# CITY OF ALBUQUERQUE

March 6, 2013

Re: Lots 34A, B, C and D  
Grading and Drainage Plan  
Engineer's Stamp dated 12-31-12 (G13/D029)

ALVARADO GARDENS UNIT 1
LOTS 34 A, B, & C
GRADING & DRAINAGE PLAN

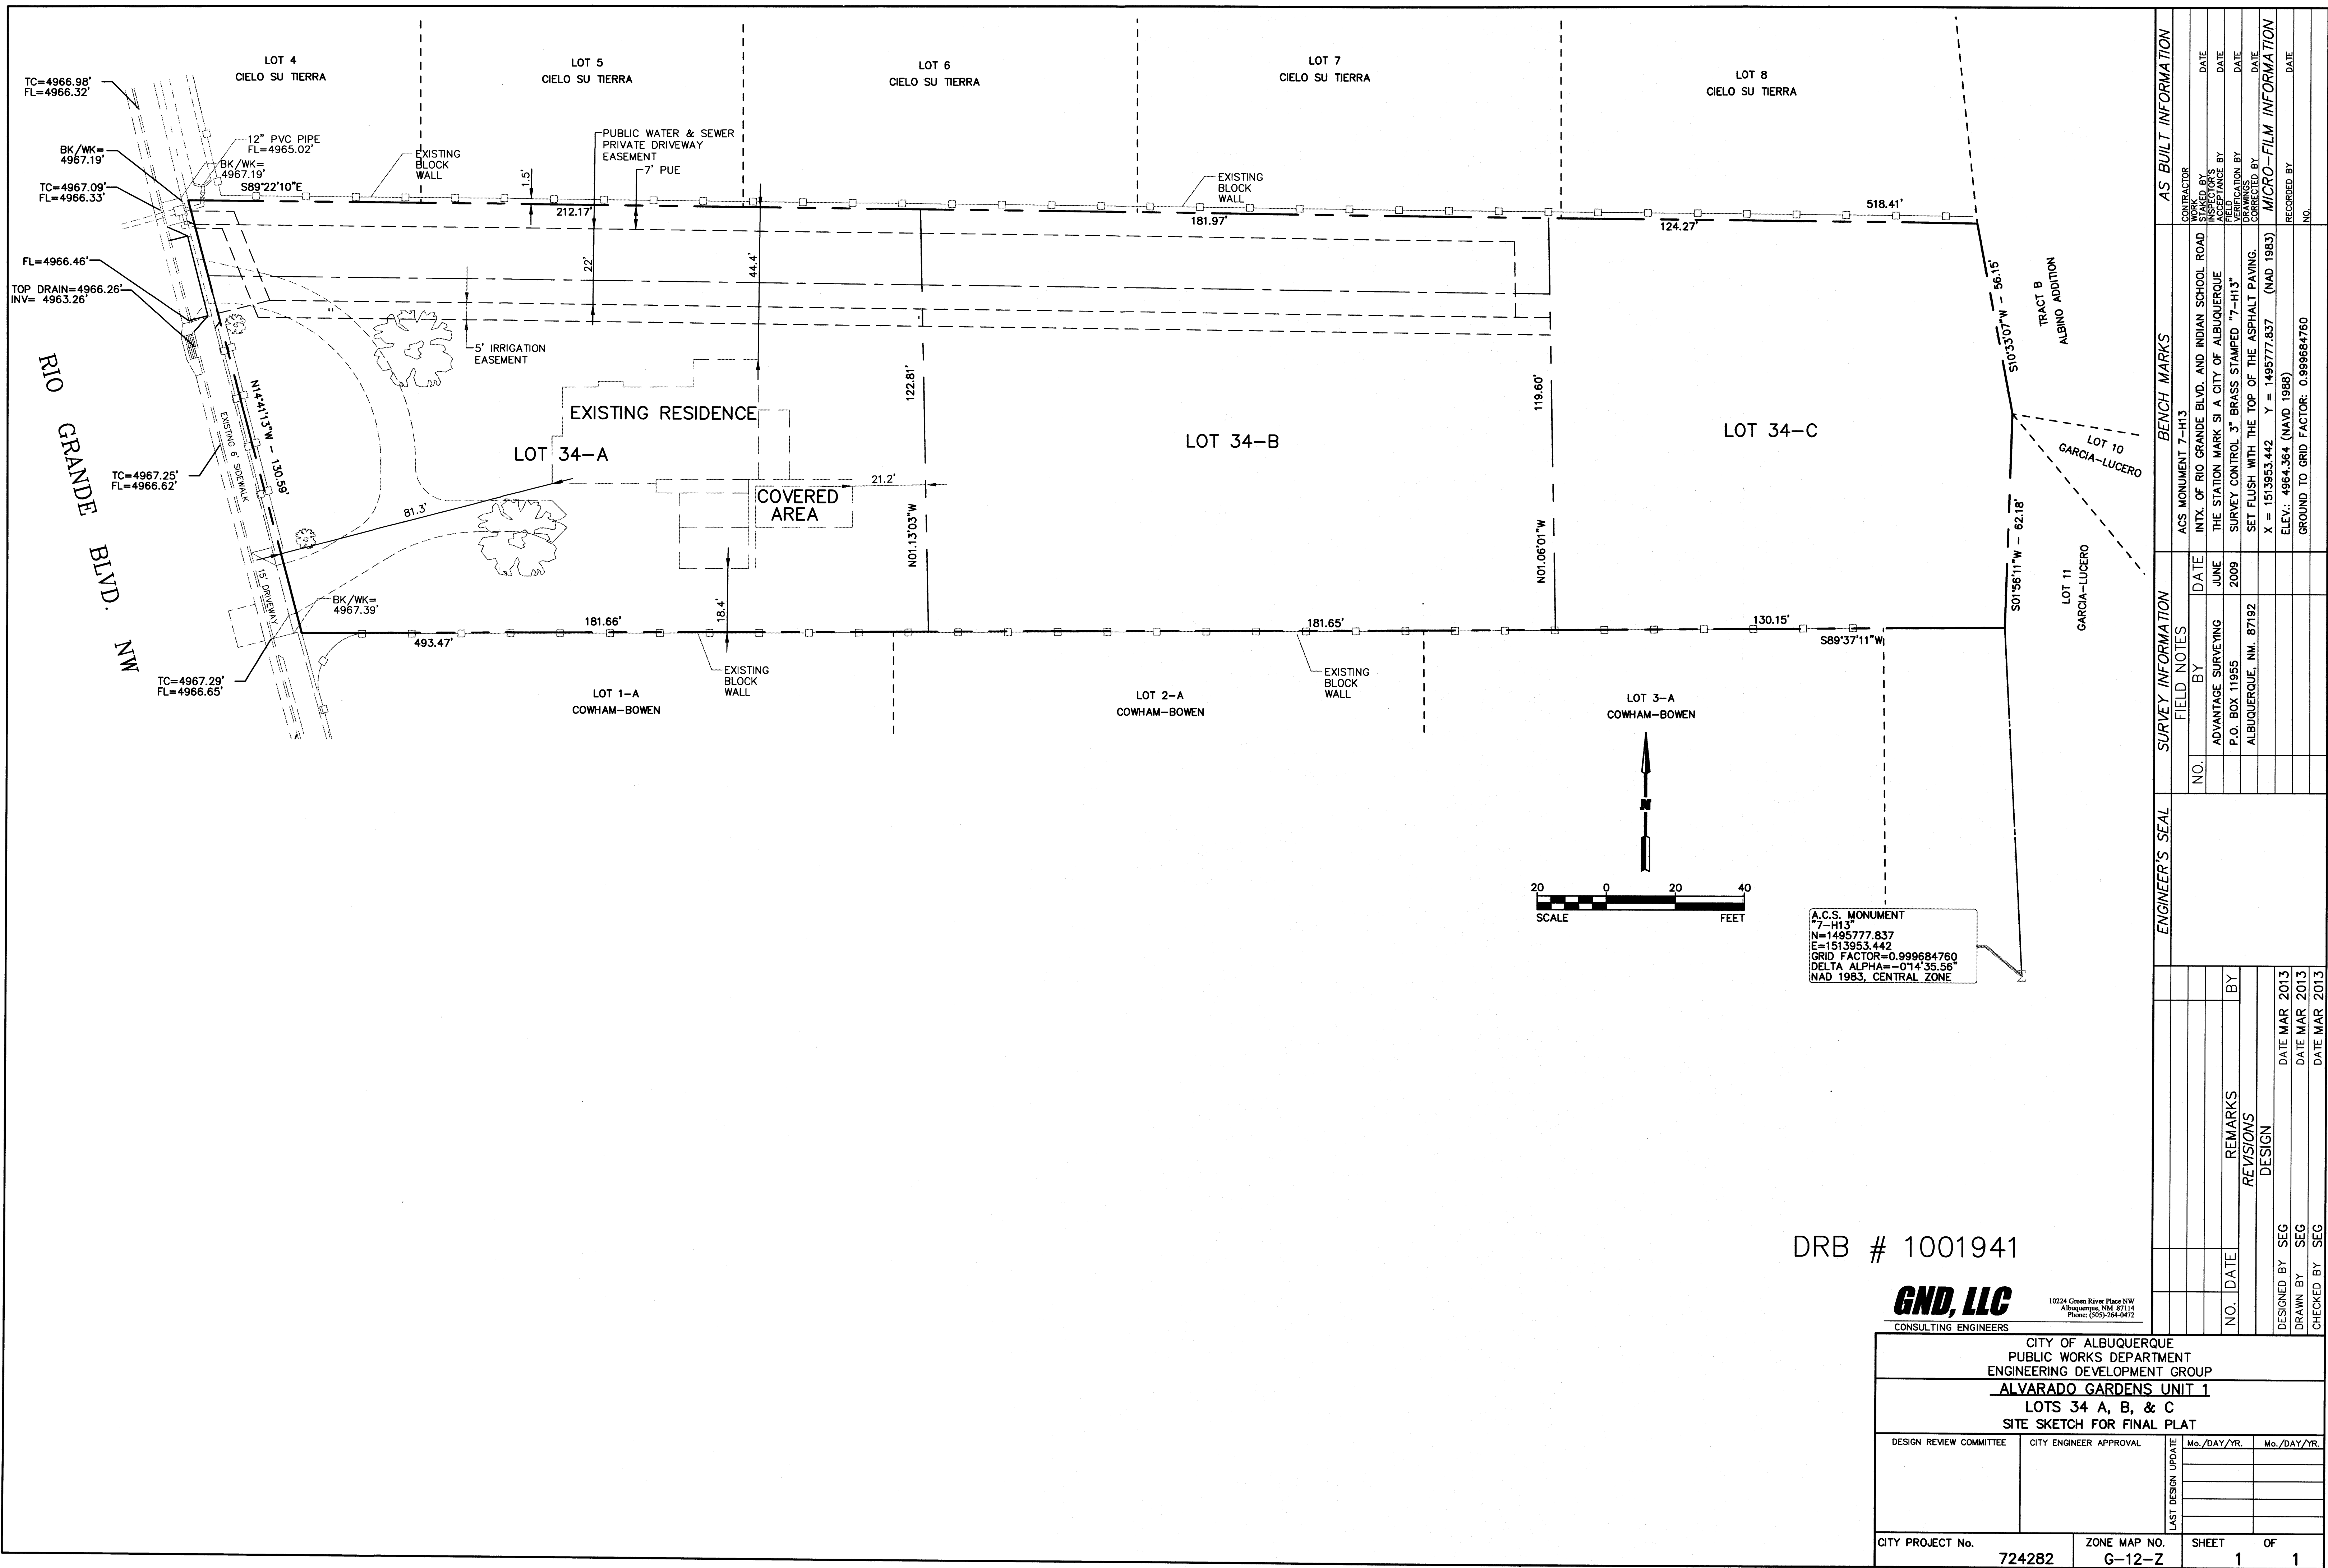
- The entrance curb cut appears to be too close to the existing inlet. Please shift entrance to the north and provide detail elevations to assure that ADA and 1' water block requirements are met.
- There are several boxes shown with piping which appears to be for the irrigation purposes. Please clarify.
- Half of the access road drains north to the 7' PNM easement and it is shown to drain east. Is the intent to keep the runoff within the easement? Does the 7' PNM easement also a drainage easement? Is half the road considered also a drainage easement?
- Please provide a copy of the plat.
